CITY OF ALBUQUERQUE

**Re: Peak Motion, 7424 Holly Ave., Grading and Drainage Plan
Engineer's Stamp Dated 11-19-12, (C-19/D057)**

Based upon the information provided in your submittal received 11-19-2012, the above referenced grading plan is not approved for Building Permit until the following comments are addressed:

C101

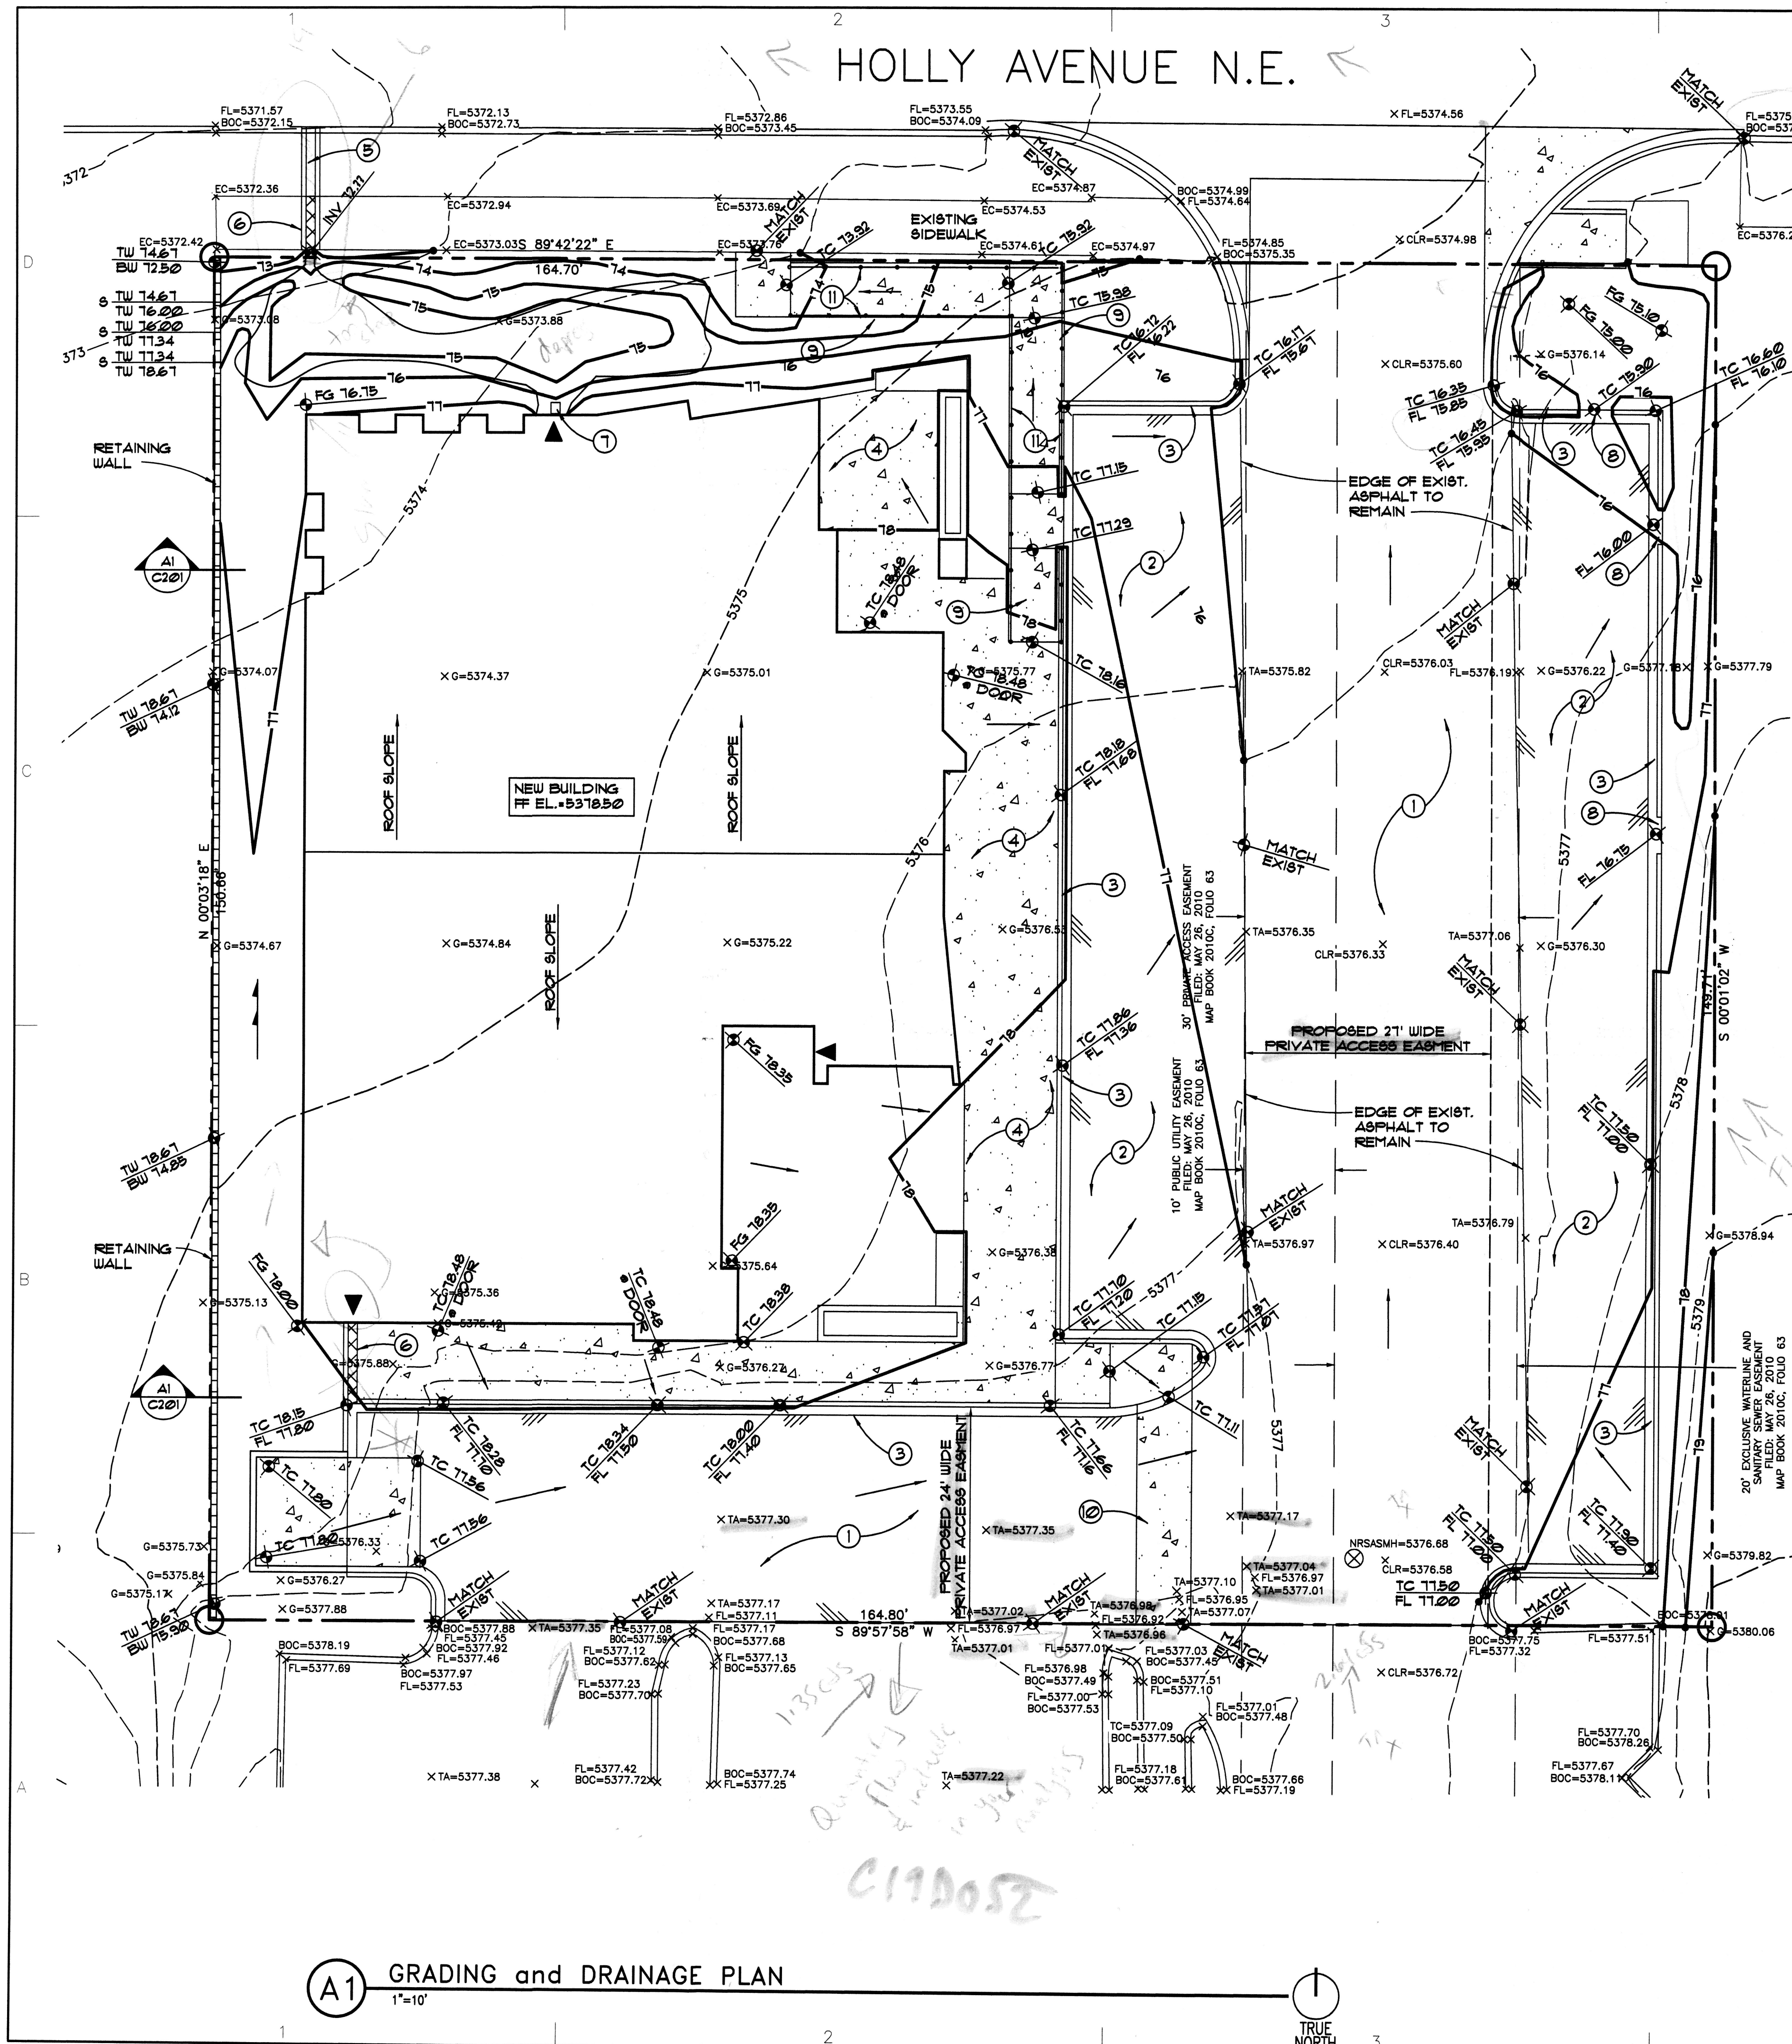
- Please quantify the flows entering the property from the south. Include these flows in your runoff calculations.
- Note #5 should be eliminated from the plan and the plate for the sidewalk culvert should extend to the curb. Add notes to extend the culvert 2 feet back from the property line to the south and to tack weld the bolts. Standard SO-19 literature should appear on the plan set.
- Identify the benchmark designation.
- Will a stem wall be required on the northwestern portion of the building? If so, details should be provided.
- We suggest that the southern roof drain be directed west and north through the landscape area rather than drain to the parking area as shown.
- Please depress the northern landscape area as it appears it is too steep as it enters the invert of the culvert as well as to assist in water harvesting.
